May 21, 1996

RE: ENGINEER'S CERTIFICATION FOR ALBUQUERQUE MAIL SERVICE (J14/D112)
SUBMITTED FOR CERTIFICATE OF OCCUPANCY APPROVAL, ENGINEER'S STAMP
DATED 5/1/96.

ALBUQUERQUE MAIL SERVICE
GRADING AND DRAINAGE PLAN

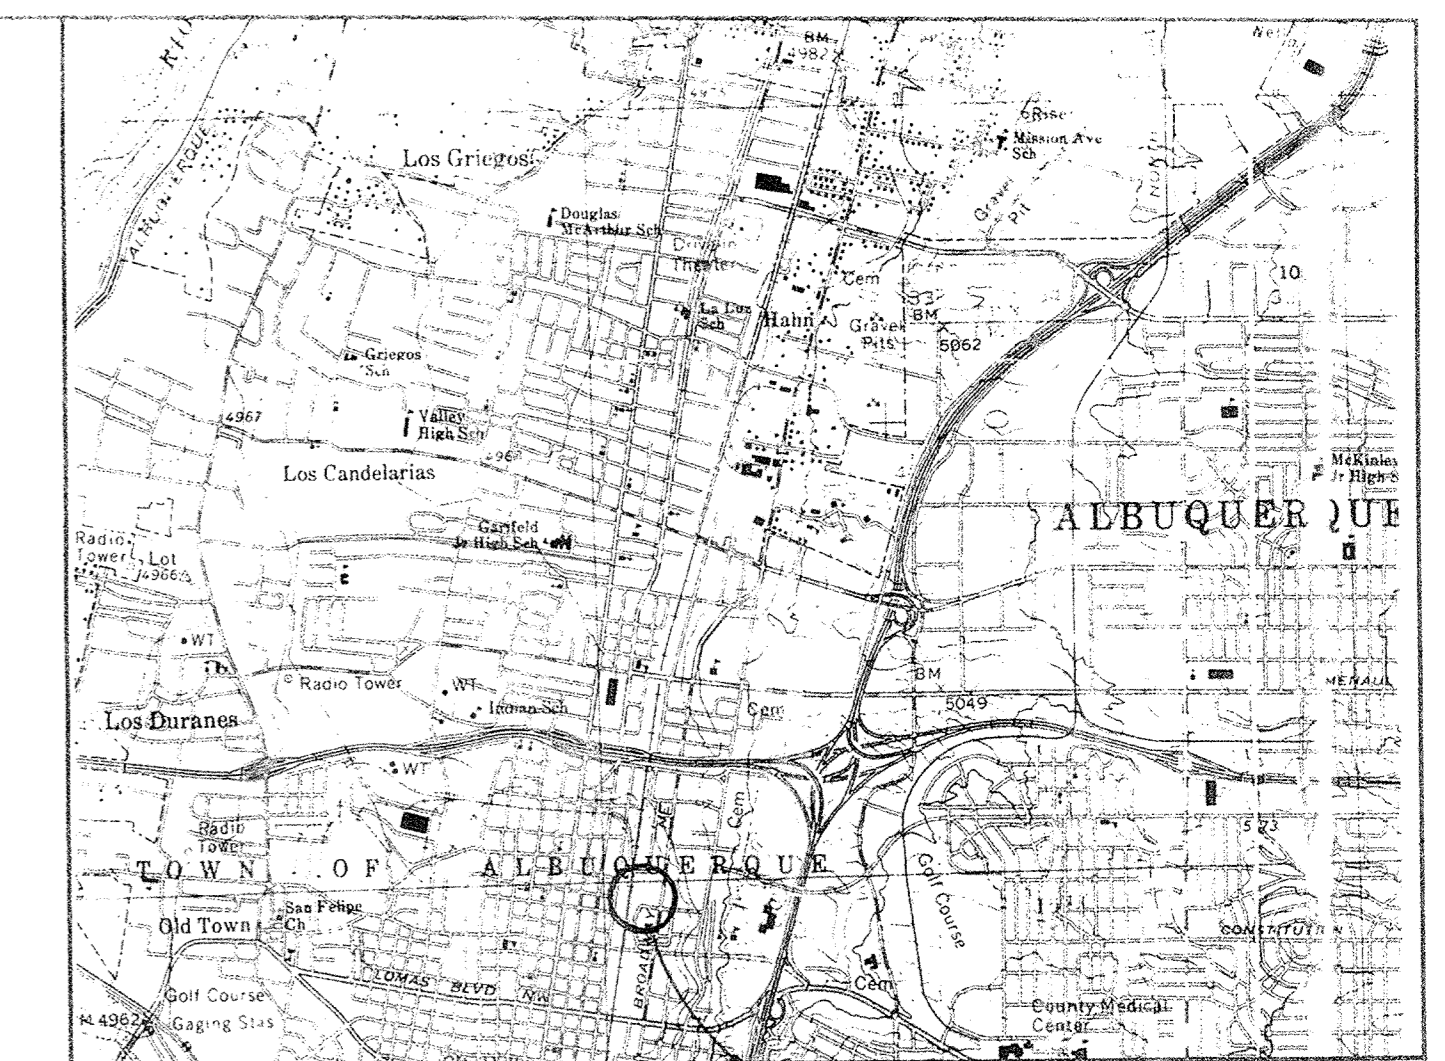
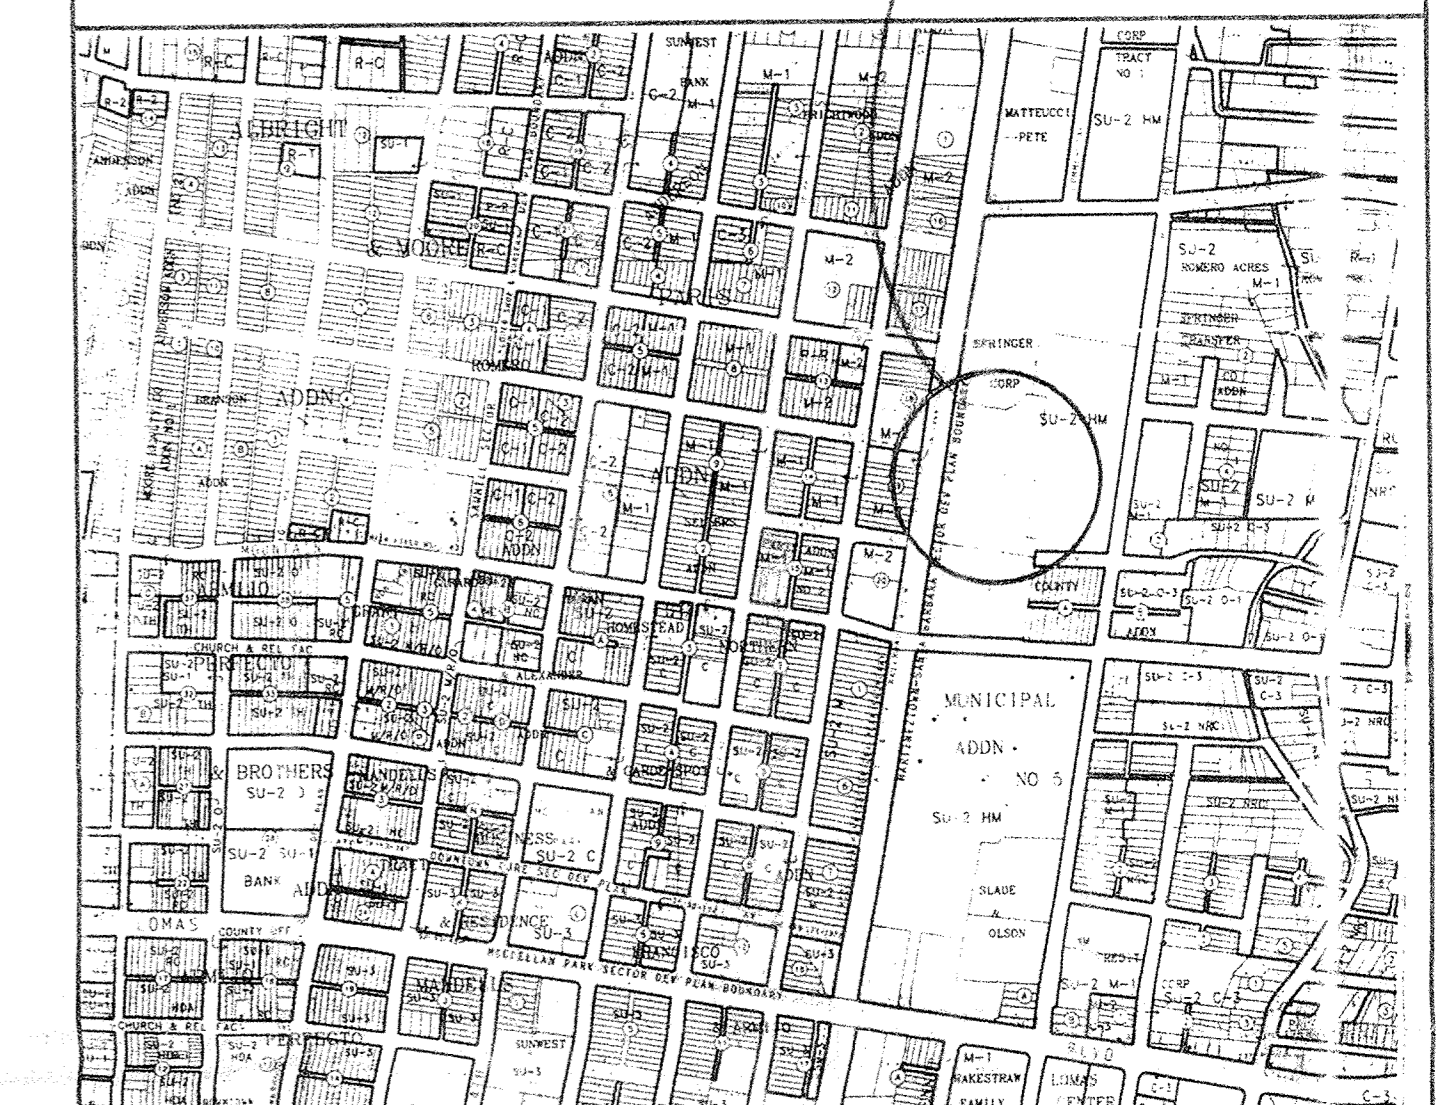
It appears that there is a submittal to the DRB to revise the lot lines for this site. Please revise this approved plan to reflect the new lot lines so that our files will be up to date.
